Response to Submissions – Cooranbong Stockpile Extension Centennial Coal Company Ltd

Prepared for: **Ron Bush** – General Manager Development & Approvals-
Centennial Coal Company Ltd
M: 0436 034 401
E: Ron.Bush@centennialcoal.com.au

Date: **04 May 2026**

Project no: **ER092**

CENTENNIAL MANDALONG Pty Ltd
COORANBONG STOCKPILE EXTENSION
VEGETATION DISTURBANCE BOUNDARY
HISTORY - PRE-FEASIBILITY OPTION
AUGUST 2023 - SHEET 2 OF 5

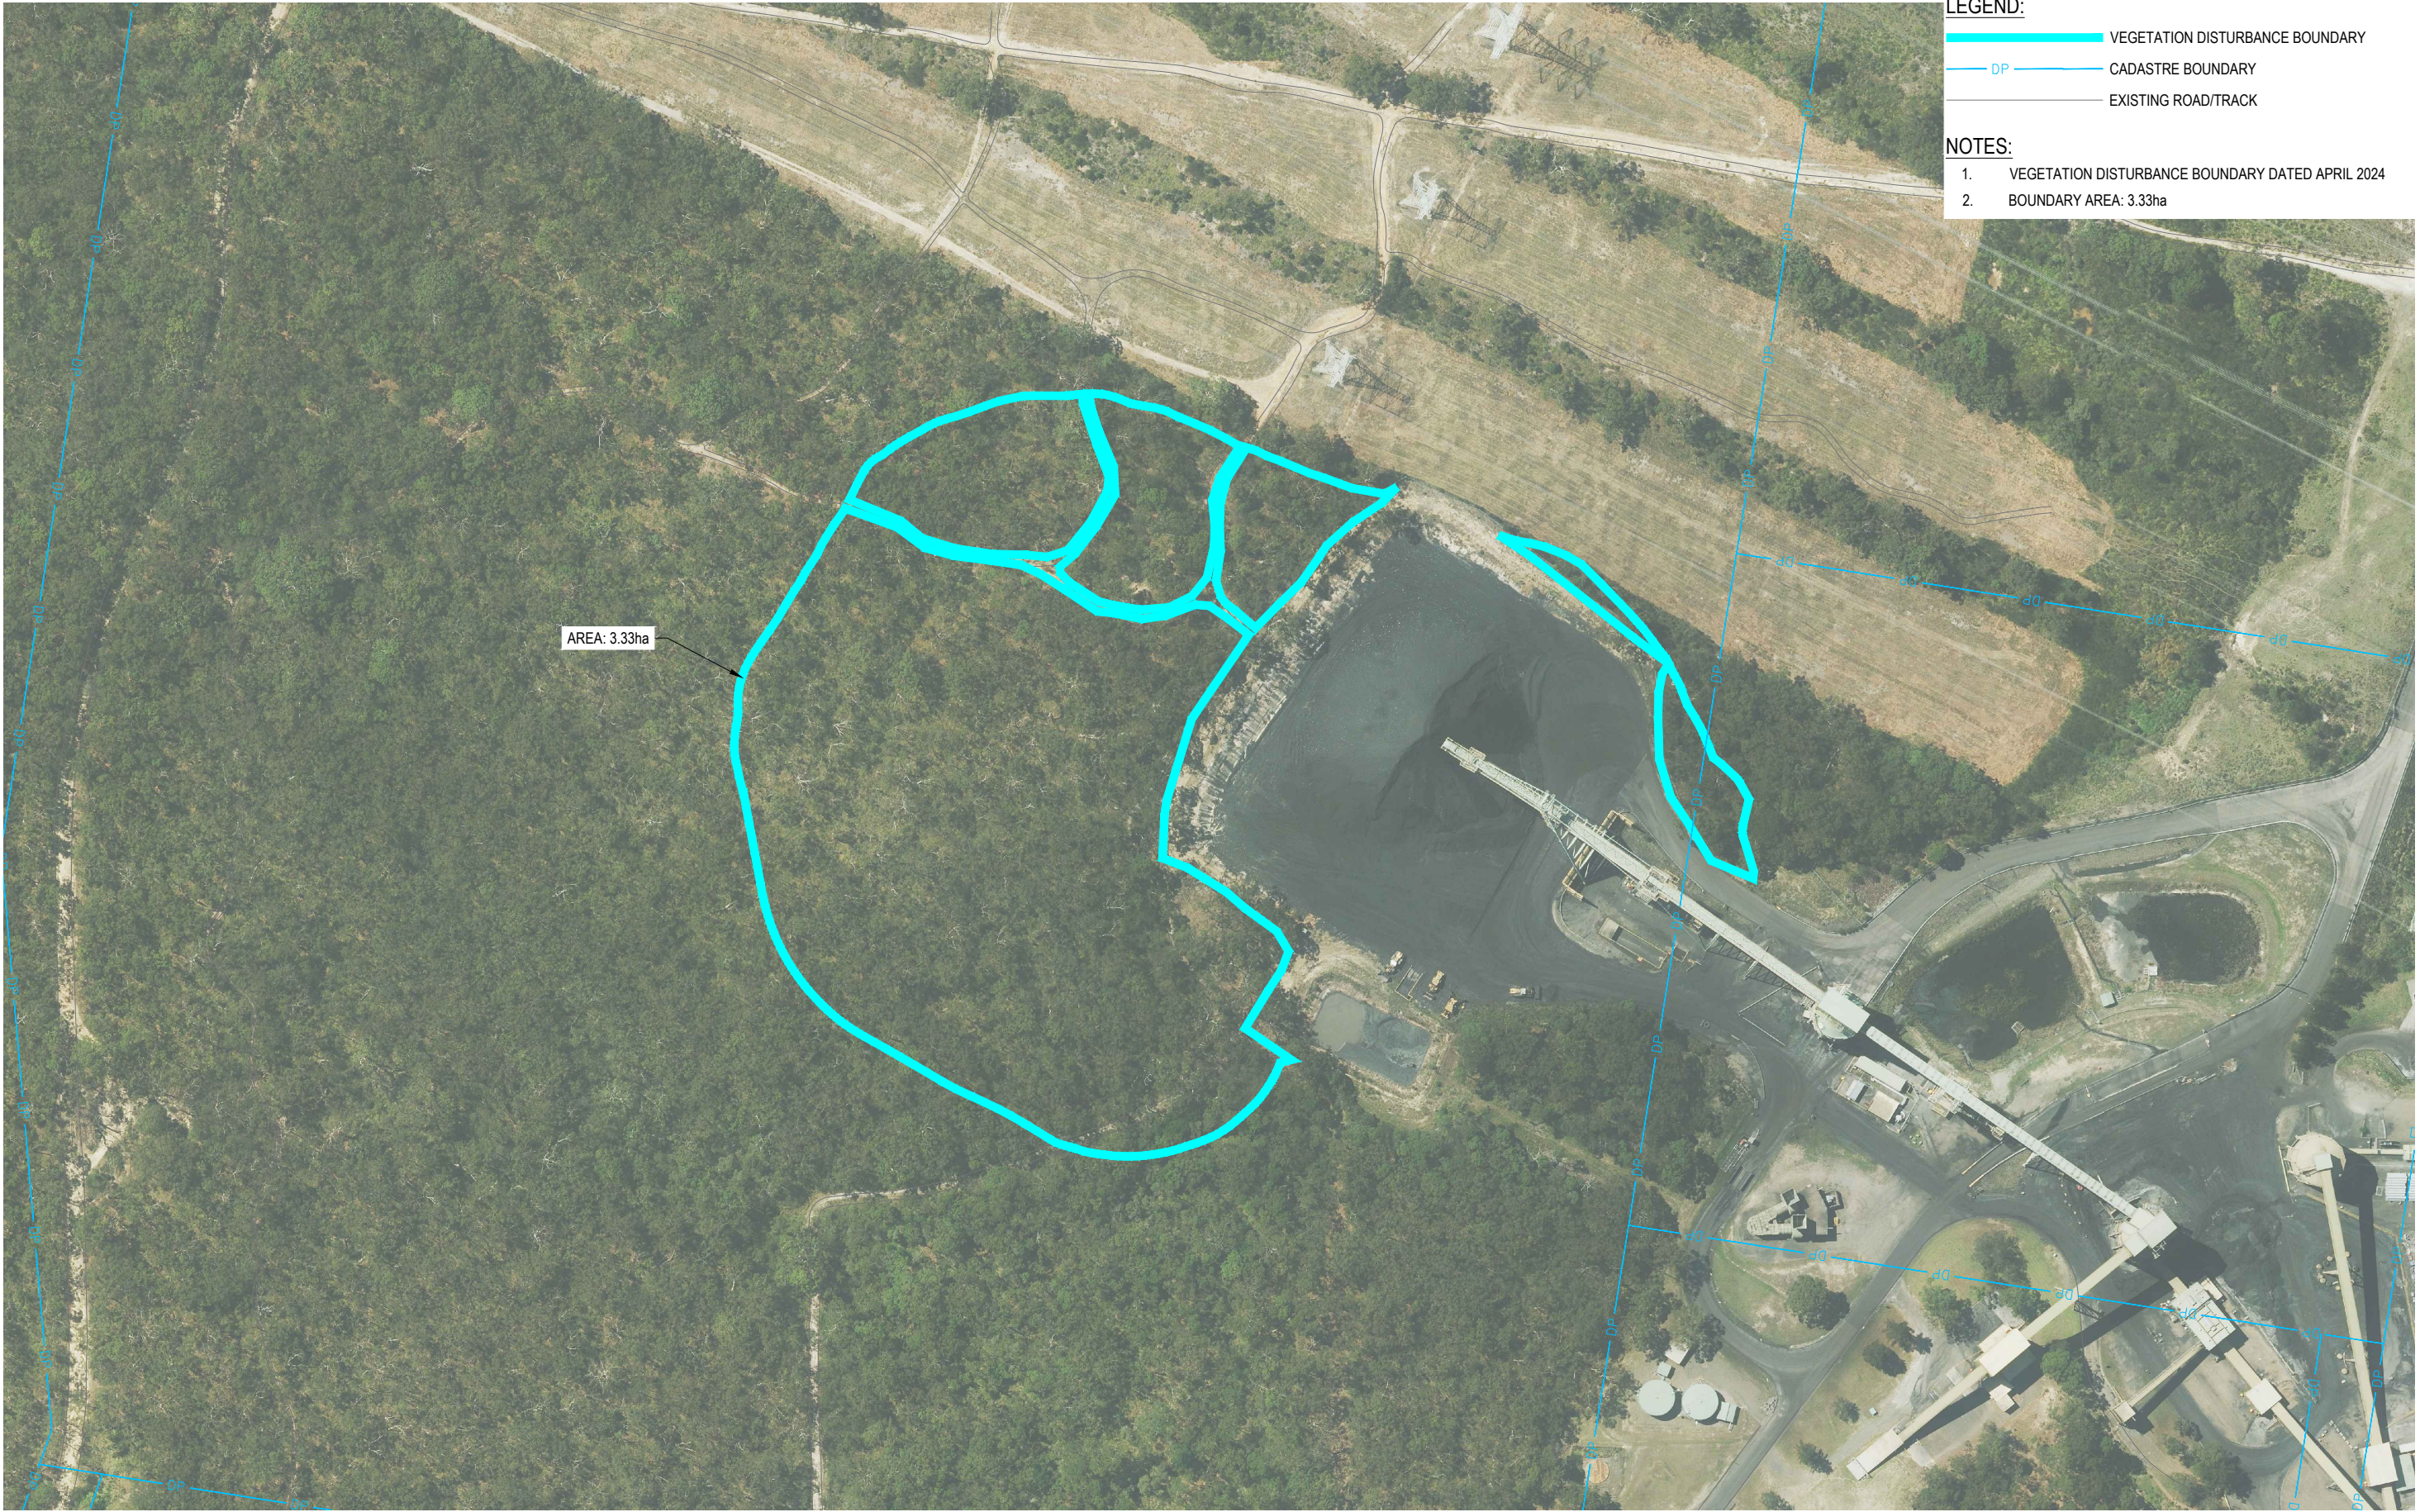
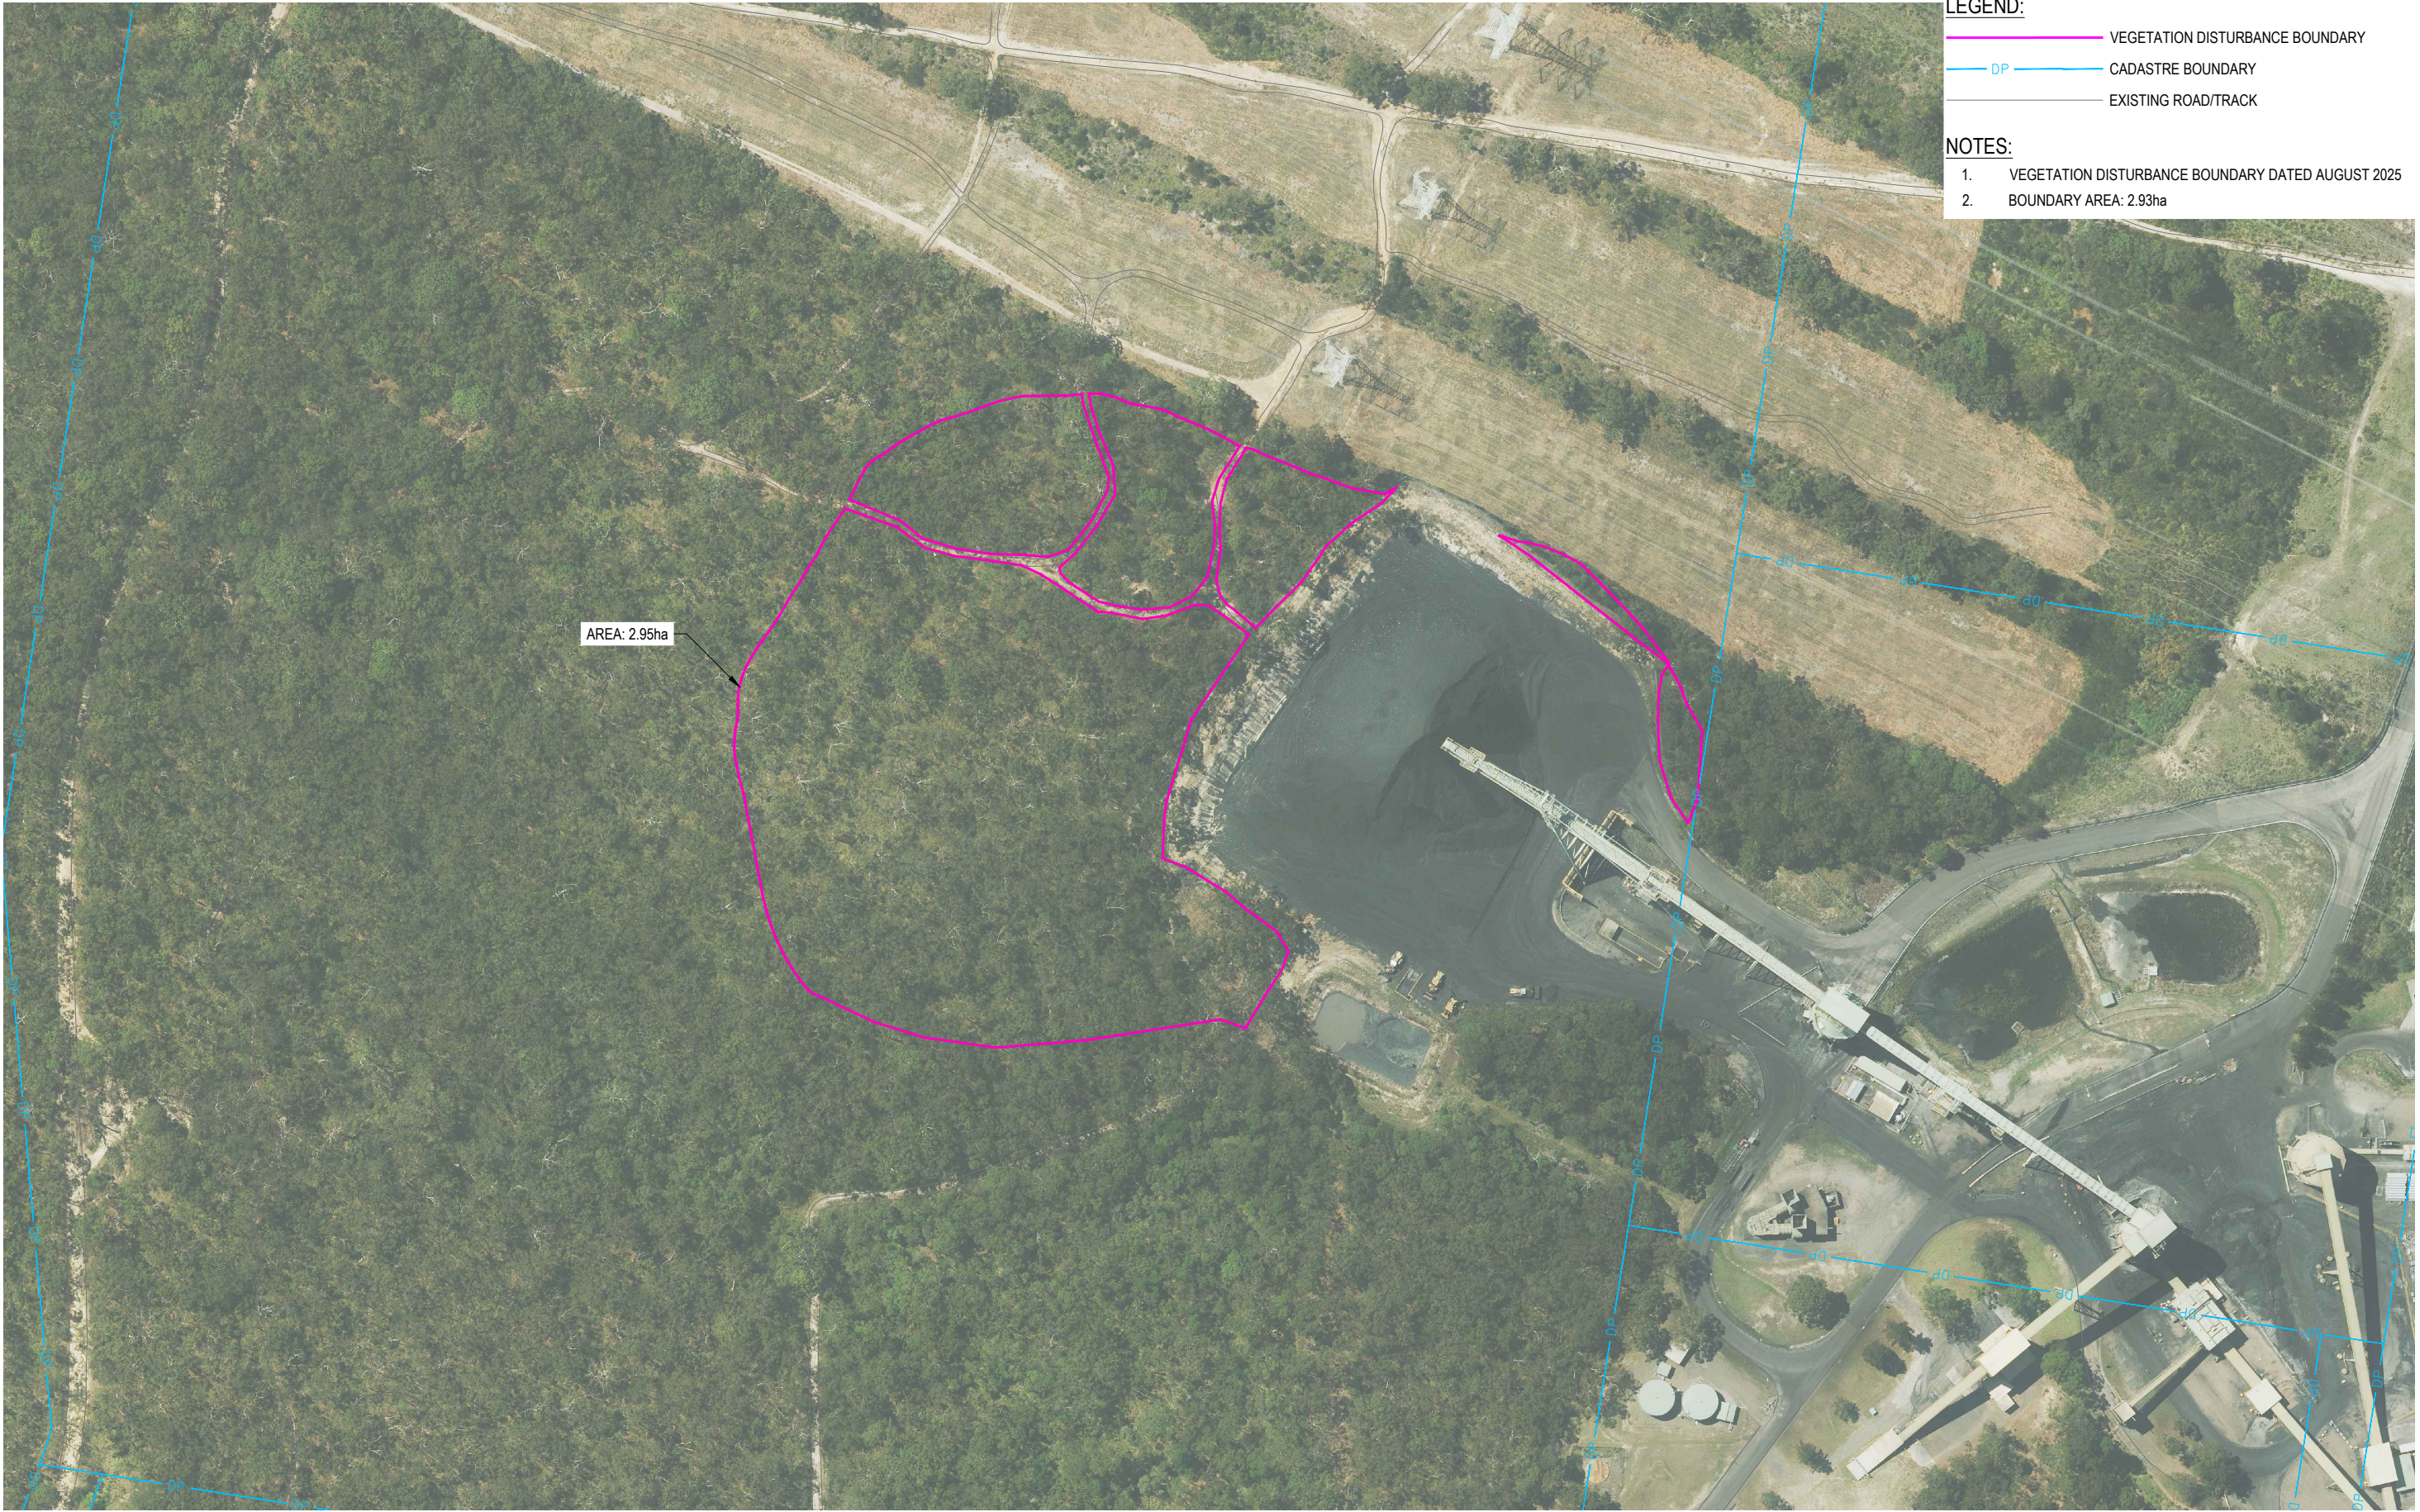
2. Inadequate avoidance and minimisation of Biodiversity issues The BDAR does not adequately address the avoid, minimise and offset hierarchy as per section 6.3A of the Biodiversity Conservation Act 2016 (BC Act). The BDAR does not identify how the significant findings of the Stage 1 BAM Assessment have informed the avoid and minimise strategy and led to impacts to biodiversity being avoided. The assessor should document the analysis and evolution of the avoid and minimise options in the BDAR (see Section 3.3 of the BAM (2020) Stage 2) to provide transparency and support decision making. The assessor needs to demonstrate how reasonable avoid and minimise measures have been genuinely and robustly explored, including an evaluation of feasible alternatives, spatial identification of areas avoided, and supporting analyses, data, and justifications for the decisions made. The BDAR lacks any substantive analysis or documentation addressing how impacts have been avoided or minimised in accordance with the BAM. Given the significant impacts to threatened species and threatened species habitat, it is strongly recommended that alternative technologies, processing methodologies, and alternative areas are explored for the stockpile expansion. A refinement in disturbance area is mentioned in the BDAR but this should be further discussed, documented and clearly mapped, as part of Stage 2 of the BAM, demonstrating that alternate locations, technologies or processing methodologies have been considered. The BDAR also needs to document how the findings of Stage 1 BAM Assessment have informed the avoid and minimise strategy. CPHR requests further avoidance of impacts to: - Threatened species (<i>Grevillea parviflora</i> subsp. <i>parviflora</i> and <i>Tetratheca juncea</i>) - Habitat features such as hollow bearing trees used by Squirrel Gliders and possibly Masked Owls and Glossy Black-Cockatoo’s. Loss of hollow bearing trees is a key threatening process. CPHR considers the loss of this high value threatened species habitat to be unacceptable given the rates of habitat loss and extinction in NSW, and the inadequate avoid and minimise strategy presented in the BDAR.	Recommended action: - CPHR recommends that alternate locations, technologies or processing methodologies are considered and genuinely explored in the BDAR to avoid impacting this area of high biodiversity value. - CPHR recommends further avoidance, with demonstration of how biodiversity constraints have informed design of the proposal. - The assessor is required to clearly present evidence of avoiding or minimising impacts on biodiversity values in accordance with Chapter 3 of Biodiversity Assessment Method 2020 Operational Manual – Stage 2. - CPHR recommends refinement of project footprint, to avoid high value biodiversity (i.e. large hollow bearing tree (HBT)s) and thereby updates to the BDAR, BAM-C and spatial package are required as appropriate.	S-BDAR	EcoResolve			We appreciate that the proposed modification has impacts to threatened species and their habitats. As described in Section 5.1, the subject land has been reduced substantially through two revisions, reducing loss of native vegetation from ~9.5 ha down to ~2.93 ha. Direct impacts to aquatic habitat have been eliminated from the proposal as well. While 2.93 ha of woodland will still be directly impacted, further reductions to the footprint of the proposed modification would negatively affect the planned future operational capabilities of the CES. We believe that a reasonable compromise has been reached between the avoidance and minimisation of direct impacts and the operational needs of the CES.
